Extending Homes
'Larkfield'
Yapton Road
Barnham
West Sussex
PO22 0AY

Please ask for: Ms Iqraa Malik
Email: iqraa.malik@terraquest.co.uk
Telephone: 01212341390
Our Ref: F/13/21/HH
Your Ref:
Date: 26th July 2021

Application for Planning Permission for Works or Extension to a Dwelling

Development: Erection of single storey side extension following the demolition of existing conservatory
Location: 43 Johnson Way Ford BN18 0TD

43 Johnson Way Ford

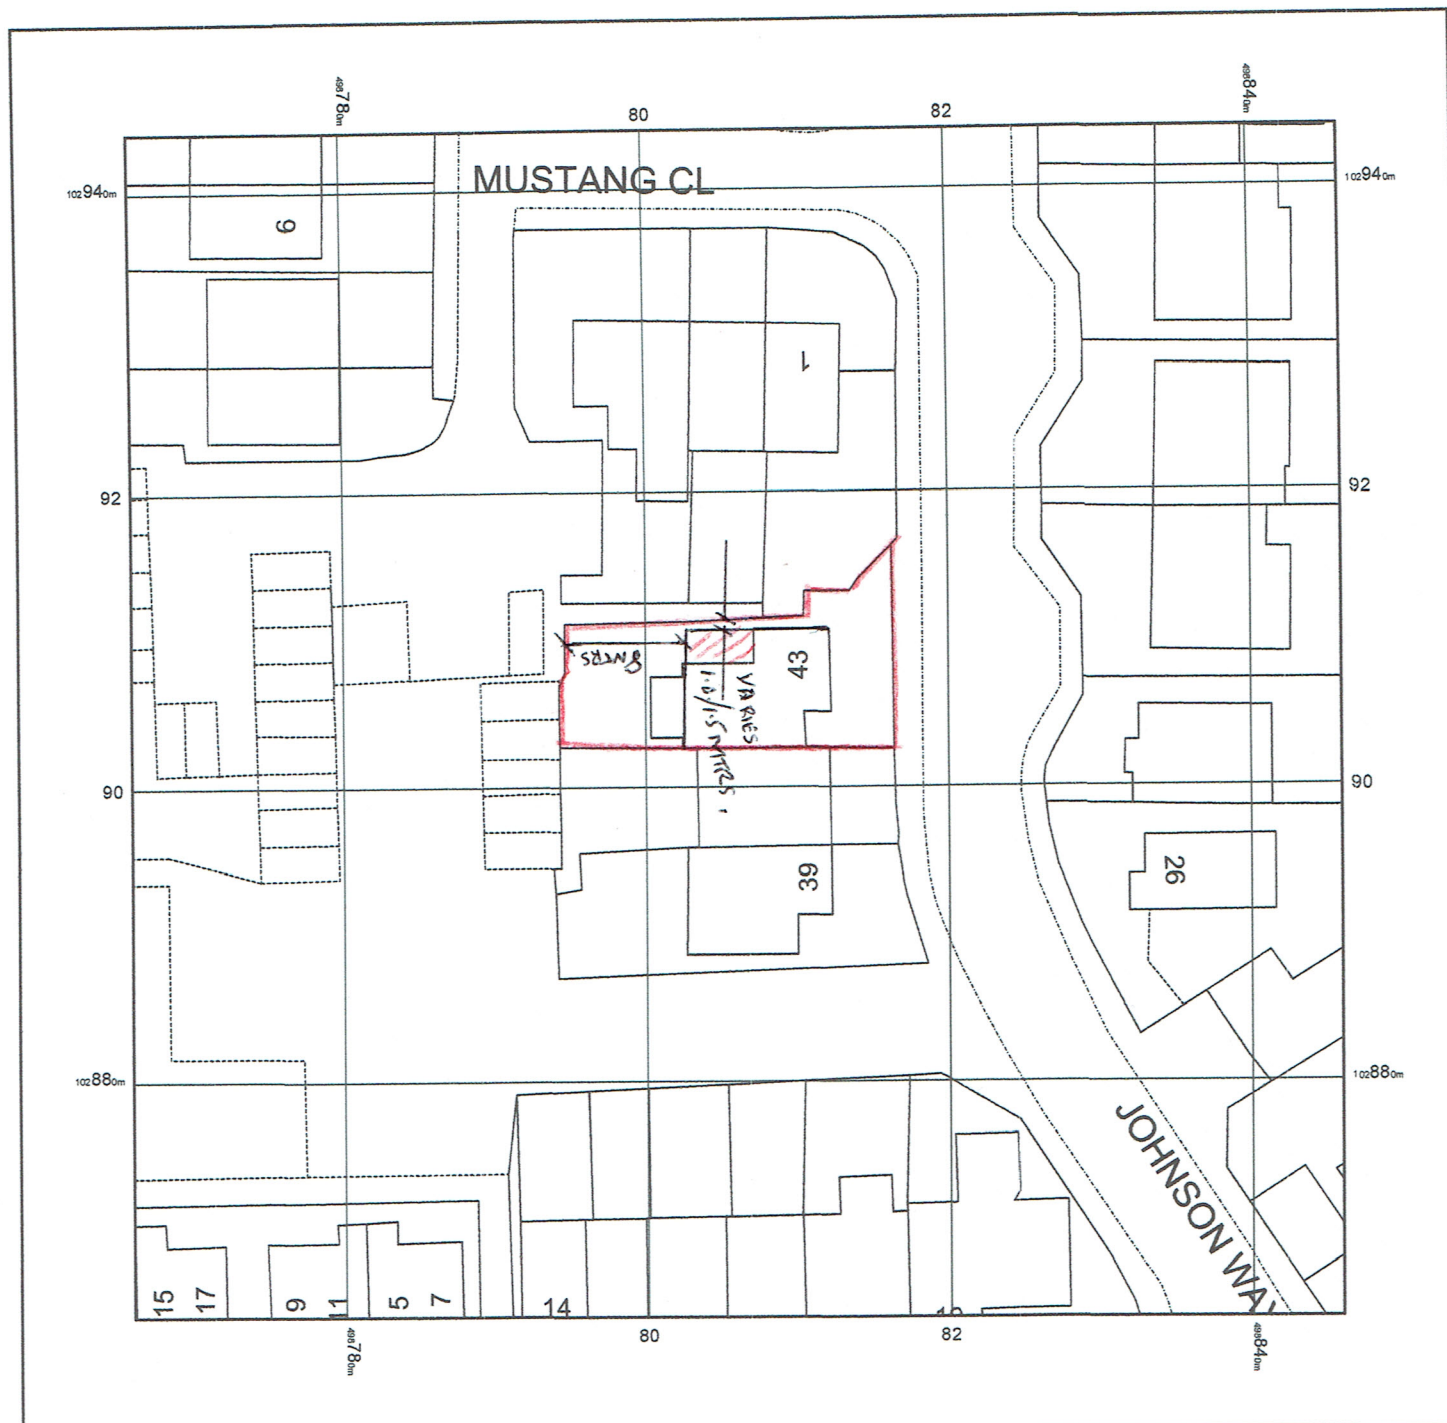
Erection of single storey side extension following the demolition of existing conservatory
Block Plan

You are required to have dimensions from the proposed extension(s) to all site boundaries. Please amend
